Appendix 1 – 11 June WSCC Public Rights of Way Letter

WEST SUSSEX COUNTY COUNCIL CONSULTATION

TO:	Arun District Council FAO: Steve Davis
FROM:	WSCC Highways - Public Rights of Way
DATE:	11 June 2026
LOCATION:	Land North of Summer Lane, Pagham
SUBJECT:	P/31/26/OUT Outline application with some matters reserved, except access, for up to 130 No residential dwellings including means of access into the site (not internal roads). This application is a Departure from the Development and affects a Public Right of Way. Amendment to the above application dated 26th May 2026 relating to:- Response Letter and updated TA
DATE OF SITE VISIT:	n/a
RELEVANT PUBLIC RIGHTS OF WAY NUMBER(S):	Footpath 100
RECOMMENDATION:	Objection
S106 CONTRIBUTION TOTAL:	n/a

Fig. 1

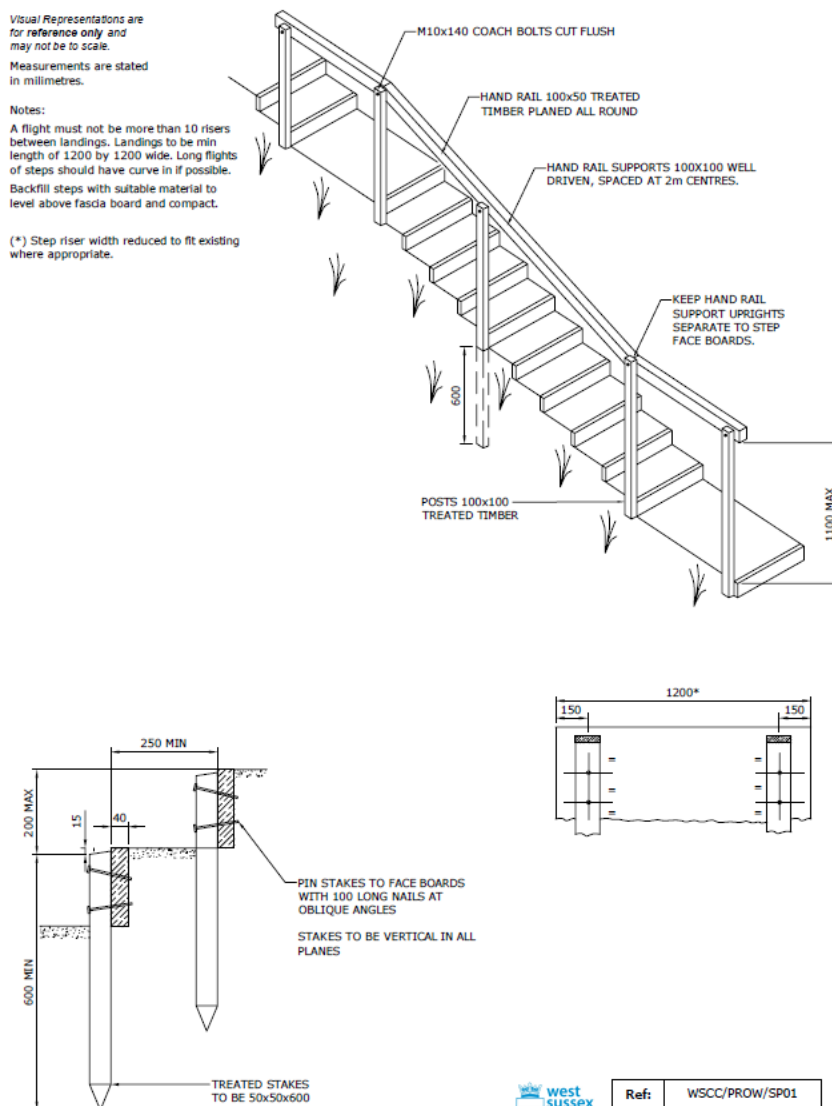
The steps are to be built to West Sussex County Council's (WSCC) Public Rights of Way (PRow) team's specification as shown below in Fig. 1.

This, along with the resurfacing of Footpath 108 to WSCC PRow's rural footpath specification (Fig. 2) should both be conditioned within any planning approval and delivered via a S278 agreement.
